Application No: SSD – 9912

Location: 27-29 and 37 Bancroft Avenue, ROSEVILLE, NSW

I wish to make a submission for the above application as I OBJECT to the proposals for the following reasons:

Figure 3.3 – Surrounding Public Transport (Bus and Train Services)

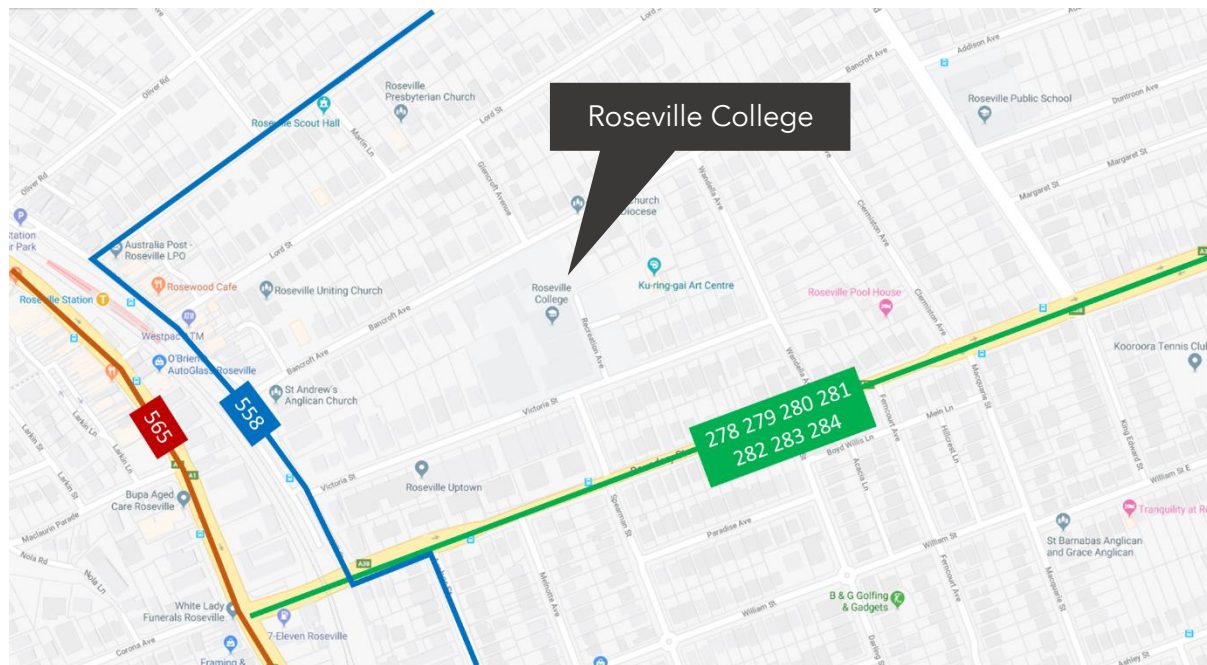
- d. Figure 3.3 of PCTMP shows Bus Route 558 incorrectly, which indicates that any site assessment by ptc Consultants was insufficient and is flawed. Bus Route 558 was altered due to the RMS upgrade of Boundary Road at the Hill Street and Archer Street intersections such that the route is now from Archer, to Wandella, to Victoria to Hill Street as shown by the route map at <https://transportnsw.info/routes/details/sydney-buses-network/558/34558>. The 558 service from Chatswood at 0750 to Roseville station should have been observed by ptc Consultants during their site monitoring of traffic. Consequently, the error by ptc Consultants calls into question the veracity of their traffic survey.

Figure 4.1 – Construction Vehicle Routes – 19m Truck & Dog (Demolition, Shoring and Excavation Stages)

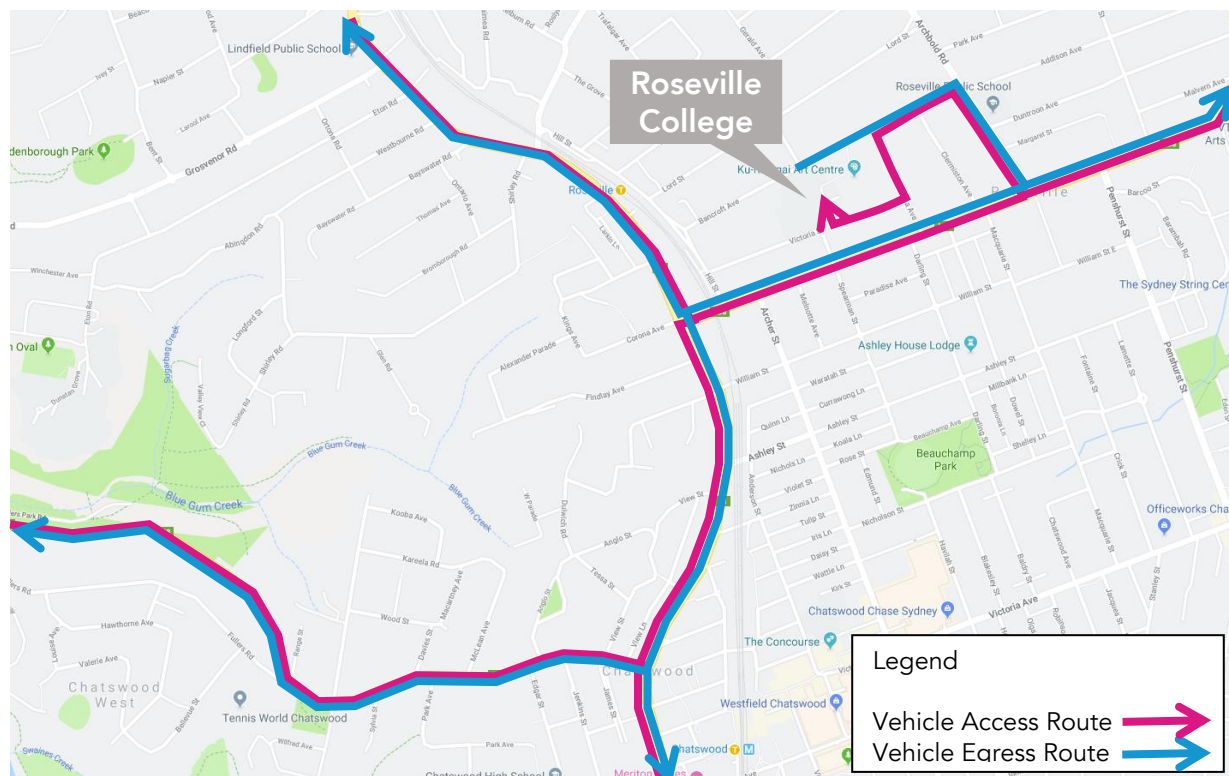
- m. It is noted that Figure 4.1 of PTCMP shows egress of the truck and dog from the proposed development site via Bancroft. The extent of excavation required will have an impact on the practicality of this proposed egress route. Egress via Recreation may be suggested later once the practical difficulties become obvious. However, the difficulty is foreseeable and the consequence of changing the egress route are significant. For clarity, if the PTCMP is to be adopted, which I consider it should not, then a Condition of Consent should be that the proposed egress route cannot be changed at a later date.

- n. Similarly, Figure 4.1 of PTCMP shows egress of truck and dog from Bancroft to Archbold heading south. In the modern idiom "good luck with that". Any observation of this intersection, particularly in morning peak hour traffic, shows the practical difficulty of achieving such a turn by passenger (sedan style) vehicles. Such a manoeuvre by a 19m truck and dog is likely to have a significant impact on traffic flow on Archbold Road in both directions and consequent impact on the safety to all involved. There will be obvious safety concerns and traffic conflicts at this intersection which are

not addressed by the PTCMP. Some form of temporary traffic management by signals and/or traffic controllers will be required for safety at this intersection whilst truck and dog vehicles are being used.

- o. I note that a relatively simple solution to the traffic and safety issues discussed above would be for the Conditions of Consent to forbid the use of 19m truck and dog during demolition and excavation and to require the use of truck only since the swept path is less onerous and would actually fit within the physical geometry of the existing intersections. Other traffic management suggestions given above could also be adopted by the Conditions of Consent if consent is given.

Figure 4.5 – Swept Path Analysis – 19m Truck and Dog at intersection 2 (Archbold Road/Bancroft Avenue)

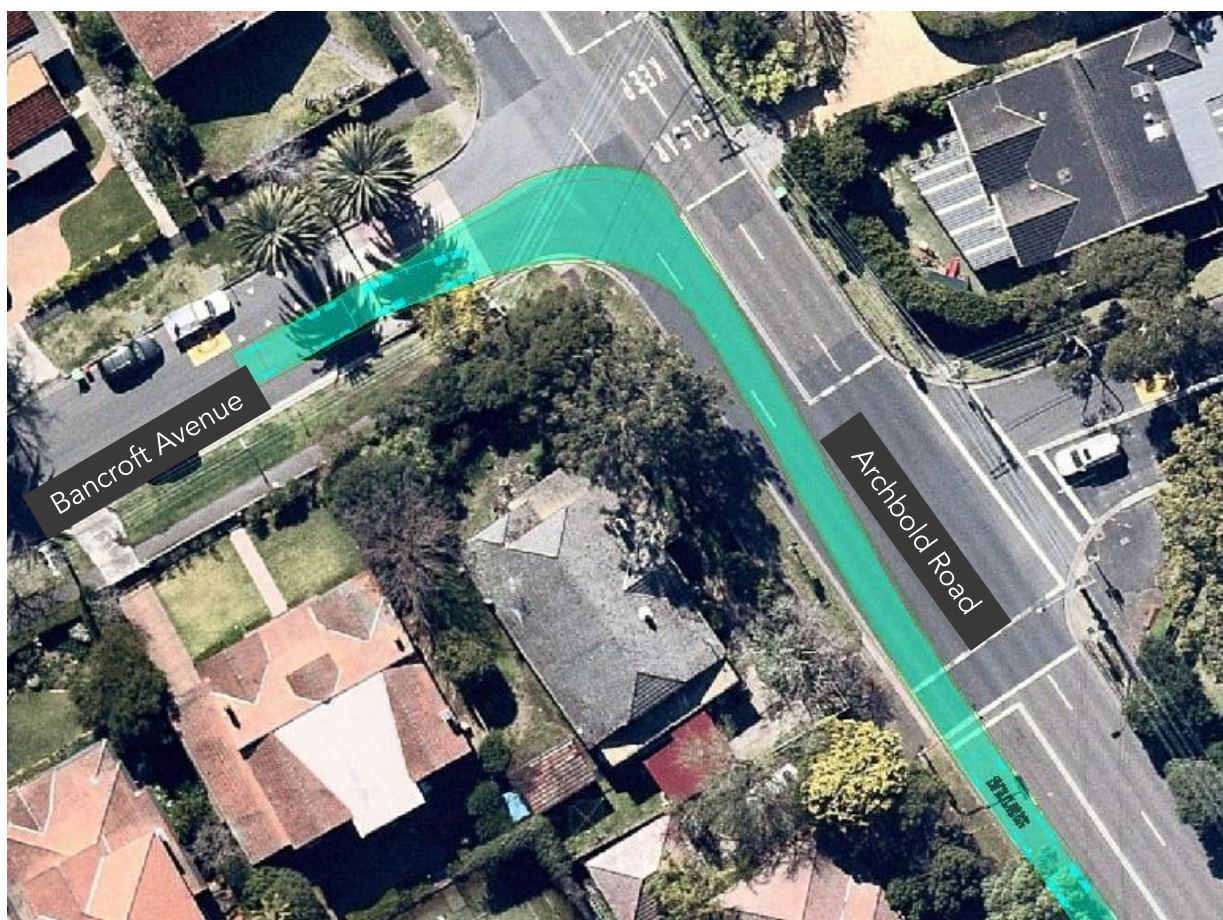
- g. Figure 4.5 of PCTMP shows the swept path for truck and dog at Bancroft / Archbold intersection (Intersection 2). The figure clearly shows there is insufficient physical geometry to avoid trailing axles impacting the southern kerb. This impact results, in part, from the physical constraint of the centre kerb at the wombat crossing. Inevitably the actual swept paths will vary with the skill of the driver. Therefore, impact on both the southern kerb and the centre kerb is inevitable with consequent high probability of physical damage due to the loads imposed.

- h. In addition, Figure 4.5 of PCTMP does not identify the effect of parked cars on Bancroft if parked close to the wombat crossing as occurs most afternoons. Such parked cars will further impact the swept path and consequent probability of damage. It would seem wise to have additional parking constraints during the use of truck and dog vehicles, but no mention is made of such a control in the

PCTMP. There are additional concerns with respect to pedestrian safety whilst drivers dropping off or picking up primary school children are accessing parked vehicles in the vicinity of this intersection, which again is not mentioned in the PTCMP.

Figure 3.3 – Surrounding Public Transport (Bus and Train Services)

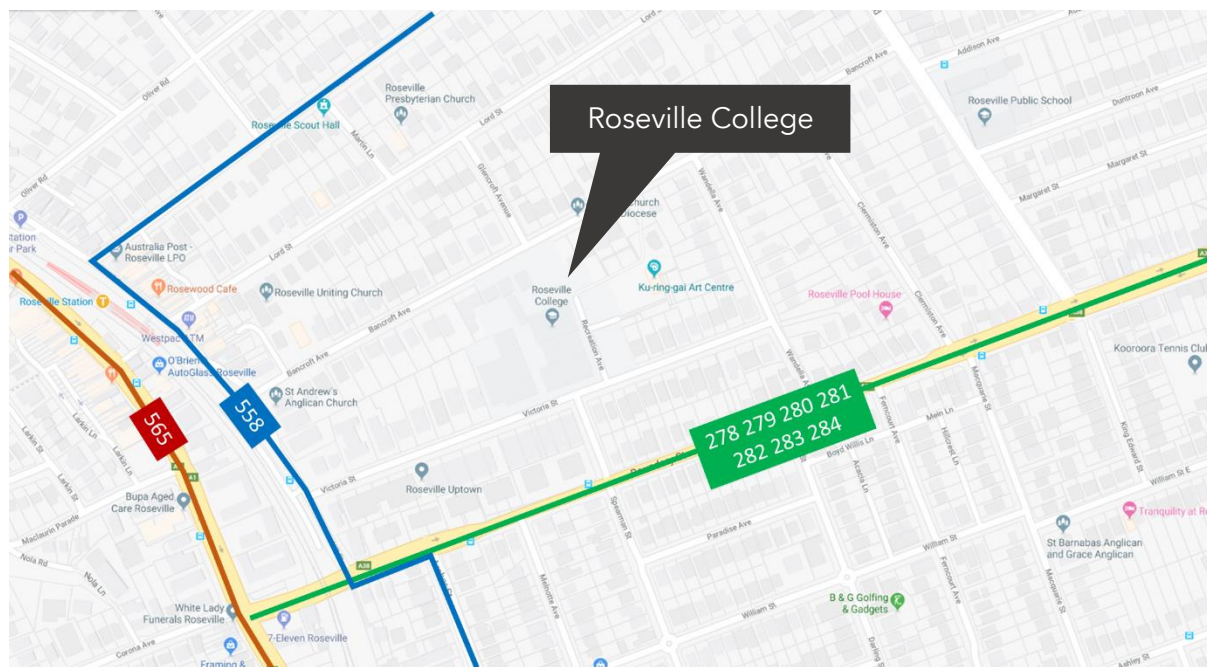
- d. Figure 3.3 of TIA shows Bus Route 558 incorrectly, which indicates that any site assessment by ptc Consultants was insufficient and is flawed. Bus Route 558 was altered due to the RMS upgrade of Boundary Road at the Hill Street and Archer Street intersections such that the route is now from Archer, to Wandella, to Victoria to Hill Street as shown by the route map at <https://transportnsw.info/routes/details/sydney-buses-network/558/34558>. The 558 service from Chatswood at 0750 to Roseville station should have been observed by ptc Consultants during their site monitoring of traffic. Consequently, the error by ptc Consultants calls into question the veracity of their traffic survey.

Figure 4.1 – Pickup/Drop-off survey results - AM

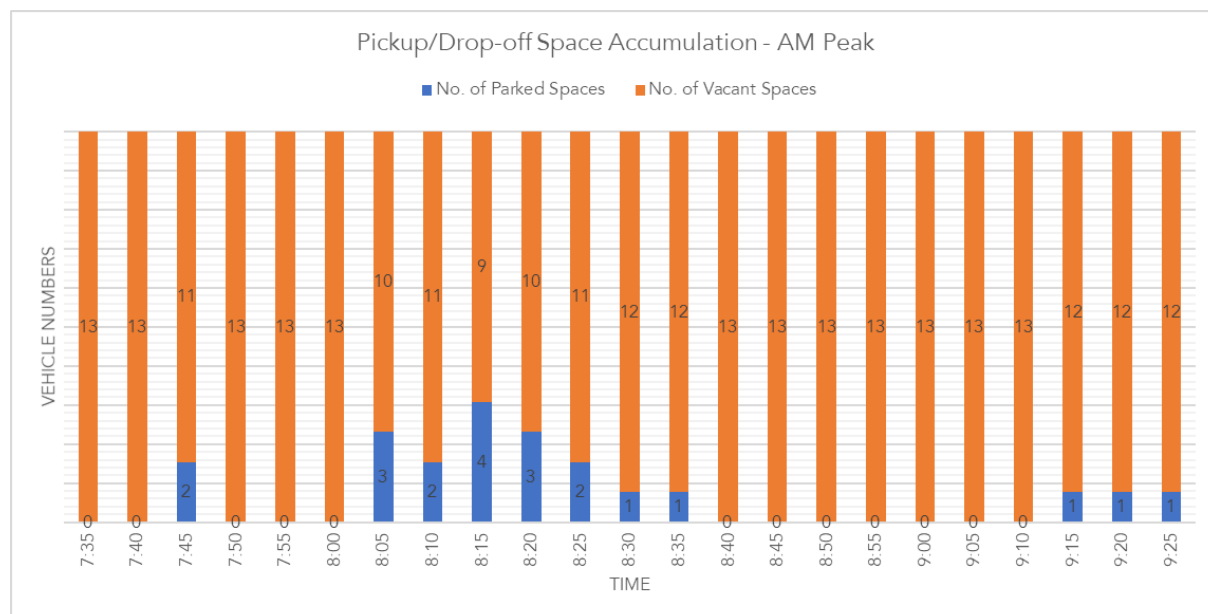
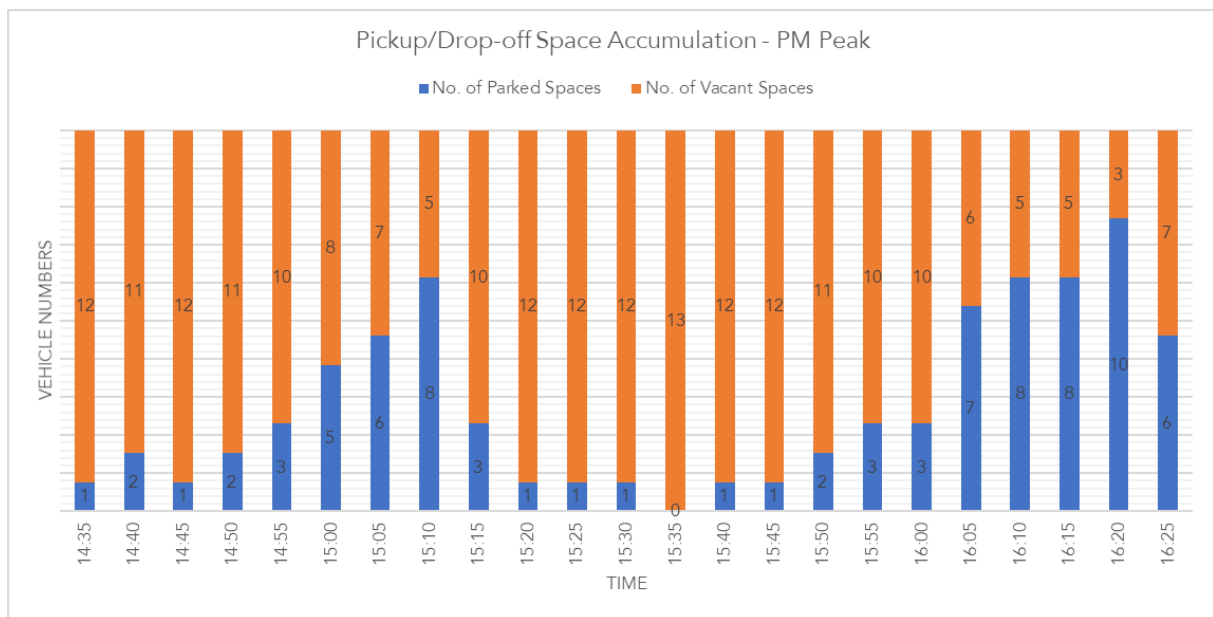
- e. Section 4.1.1 of TIA does not identify when the traffic surveys for drop off and pick up were carried out. Since Section 5.1 of TIA in relation to existing traffic conditions was based on a single survey on 26/3/19, it would be reasonable to assume that Section 4.1.1 survey was also carried out at the same time, ie assumed to be on 26/3/19. In my opinion the survey is a single “snap shot” and there is no evidence to demonstrate how reliable the “snap shot” might be. In fact, the results presented

in Figures 4.1 and 4.2 are misleading in relation to traffic and parking conditions observed virtually every day in Victoria Street. The results appear particularly misleading for the chaos during afternoon pickup when many SUV vehicles are trying to find a spot for pick up on Victoria and seriously impeded traffic flow in both directions to the detriment of local residents attempting to use Victoria Street to gain egress from the area.

Figure 5.2 – Existing PM Peak Traffic Volumes

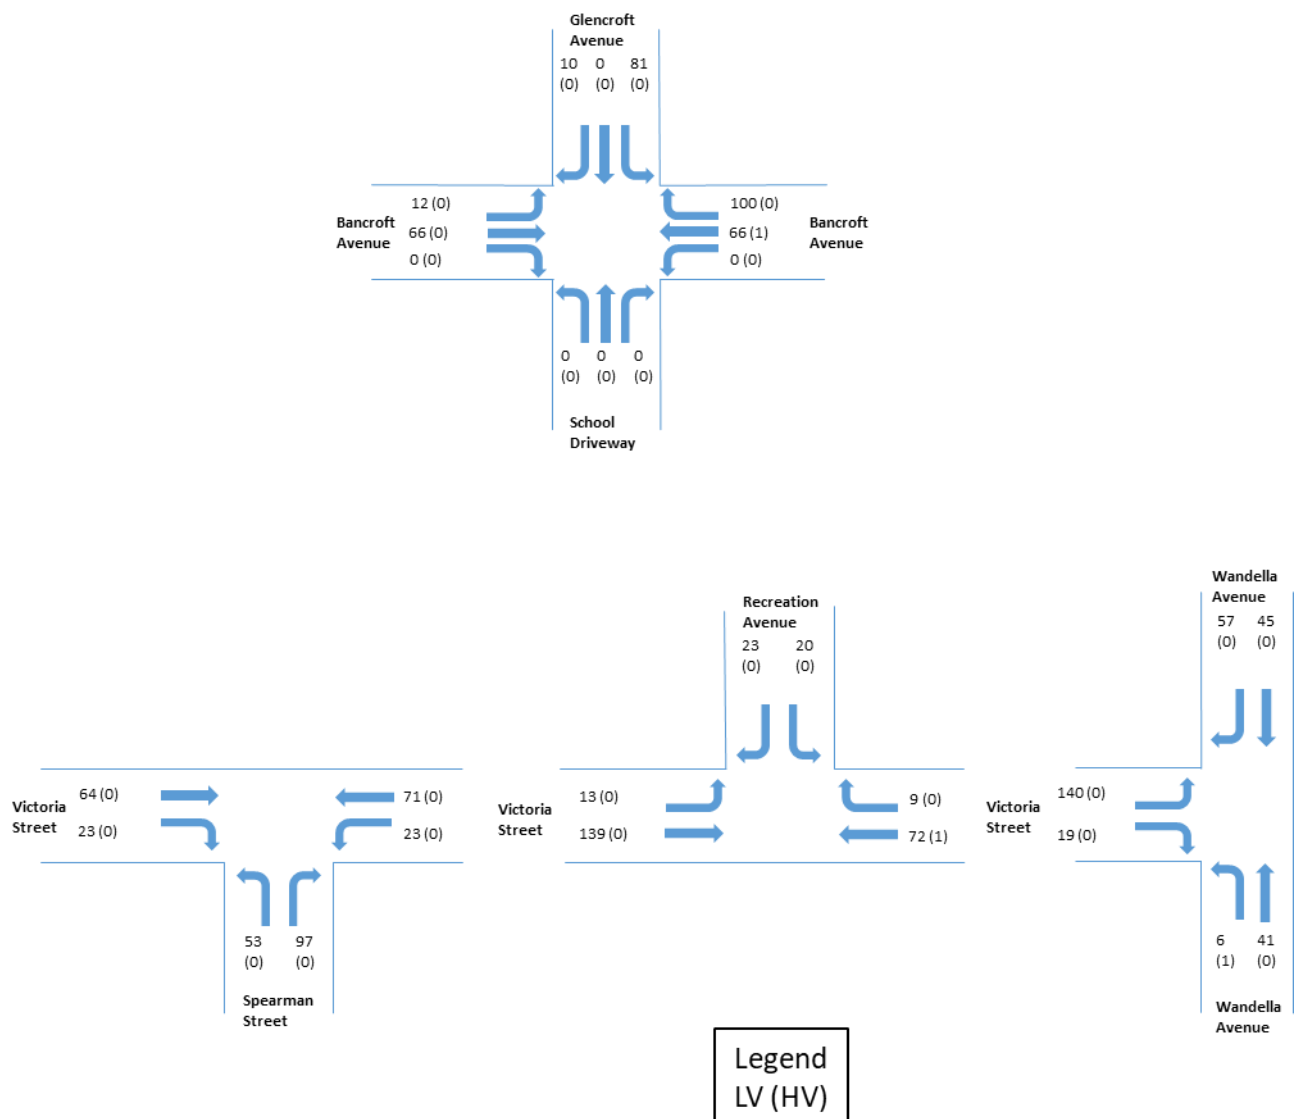
- j. Section 5.1 of TIA: data in Figure 5.2 has been selective as to the timing presented; viz 3:15 to 4:15pm. Figure 4.2 of TIA shows that a significant proportion of Victoria Street traffic occurs before 3:15pm. From 14:50 to 15:15 there are at least a further 24 vehicle movements in addition to those presented in Figure 5.2. Full data should be presented for Assessment, not a selected data set which appears to be skewed.

Figure 5.3 – Existing AM Peak Traffic Volumes with Development Traffic

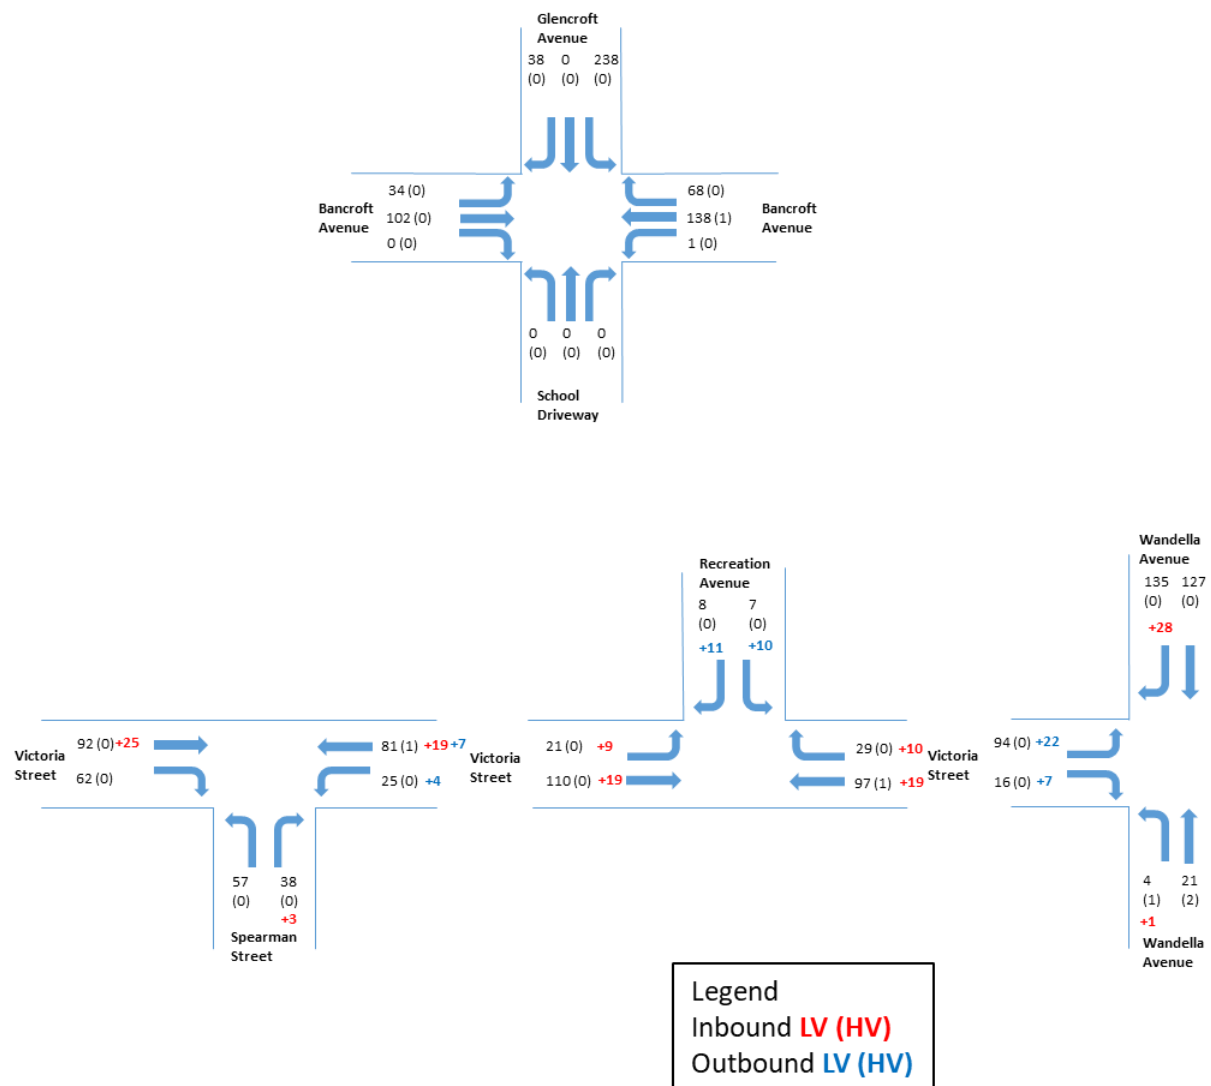
- p. By way of additional comment, Figure 5.3 of TIA addresses future traffic at Wandella / Victoria intersection in the morning peak (selected times only). This intersection is impacted significantly by traffic in Wandella which includes "rat runners" attempting to avoid traffic pinch points on Pacific Highway. Traffic on Boundary has a direct impact on egress traffic from Wandella, frequently resulting in delays and tail backs on Wandella past the Wandella / Victoria intersection which in turn cascades back into Victoria traffic flow. A more extensive traffic survey would have identified this fact. In addition, increased traffic flow on Boundary over time (to 2030) would have a significant impact on the conclusion that the traffic impact of the proposed development would be minor. In addition, although there is now no morning peak hour Right Turn from Wandella into Boundary, not all traffic obeys this, causing lengthy delays on Wandella tailing back. This factor has not been acknowledged / addressed by TIA.
